**From:** Charlotte Watkins  
**Sent:** 01 November 2021 10:19  
**To:** Rebekah Morgan  
**Cc:** Andy Bateson  
**Subject:** RE: Bicester Motion - Experience quarter

**Dr Charlotte Watkins**  
**Ecology Officer**  
Tel: 01295 227912  
Email: [Charlotte.Watkins@Cherwell-DC.gov.uk](mailto:Charlotte.Watkins@Cherwell-DC.gov.uk)

Figure 45. Proposed Automotive Demonstration And Driver Experience Diagram (not to scale)

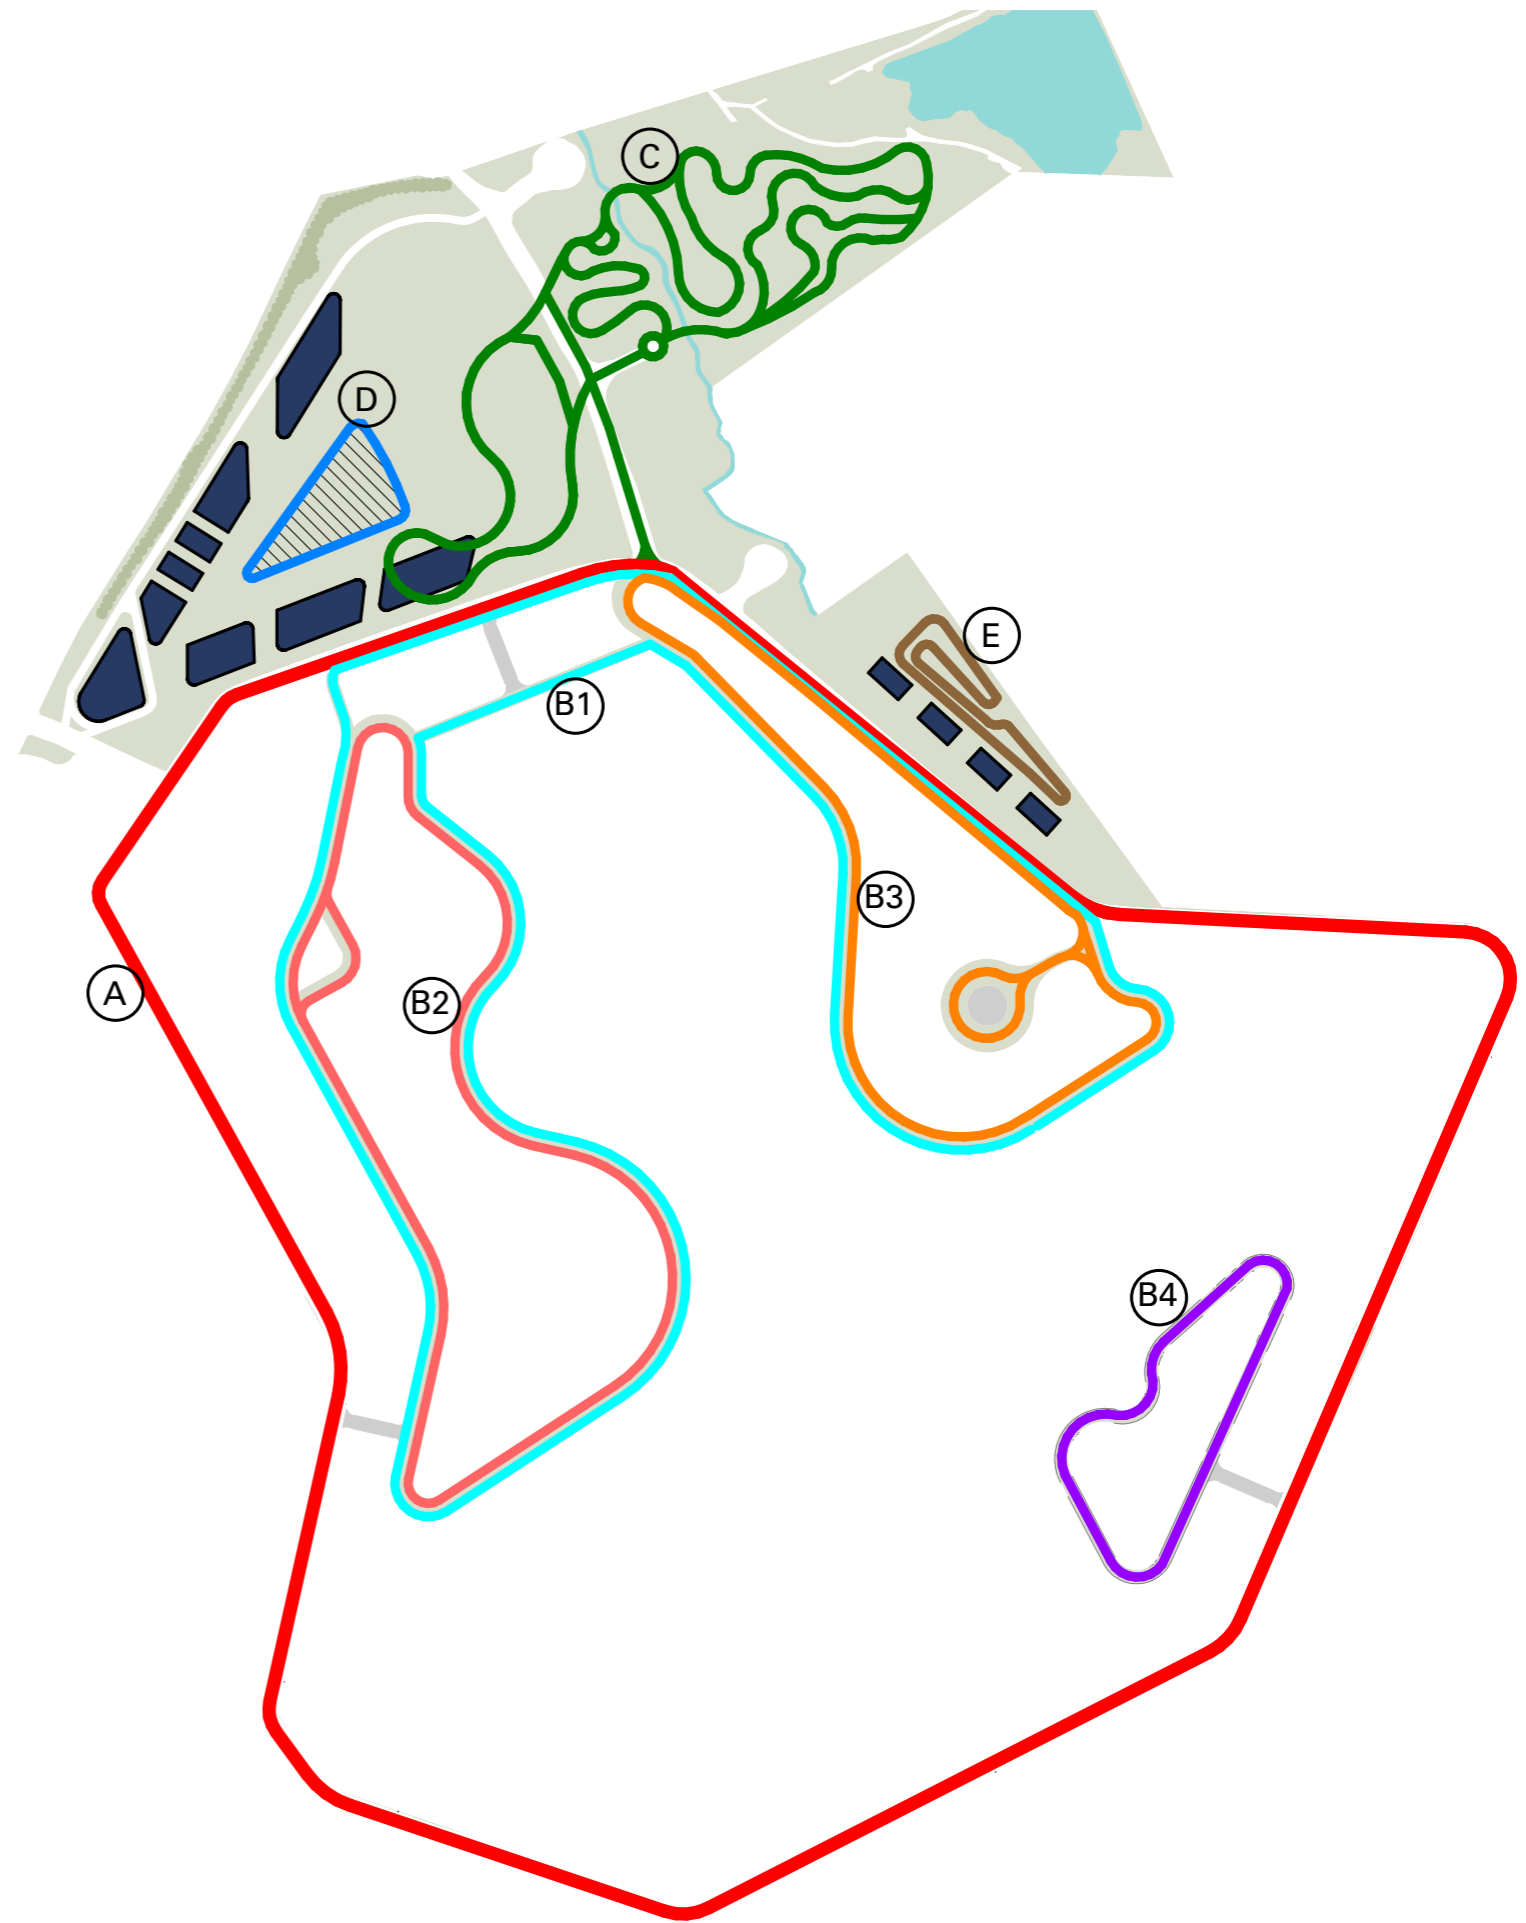
The current proposals entail loss of parts of the LWS habitats and therefore alternative options to this loss should be considered (for example outlining why at least some of the building footprint cannot be largely outside the LWS boundary). Where there is no alternative however, mitigation needs to be proven to be achievable. Mitigation here and net biodiversity gain depends largely on the applicants ability to create and maintain areas of Open Mosaic Habitat on site – at the side of the 4 x 4 track for example. It is not clear to me if all of these areas will be suitable for achieving OMH (in good condition) when operational given their proximity to vehicle movement and the likely kick up of sediment, footfall and exhaust pollution around the track? What is the 'battle' track to be made of? Will drivers stay on this track or will there be some off road driving?
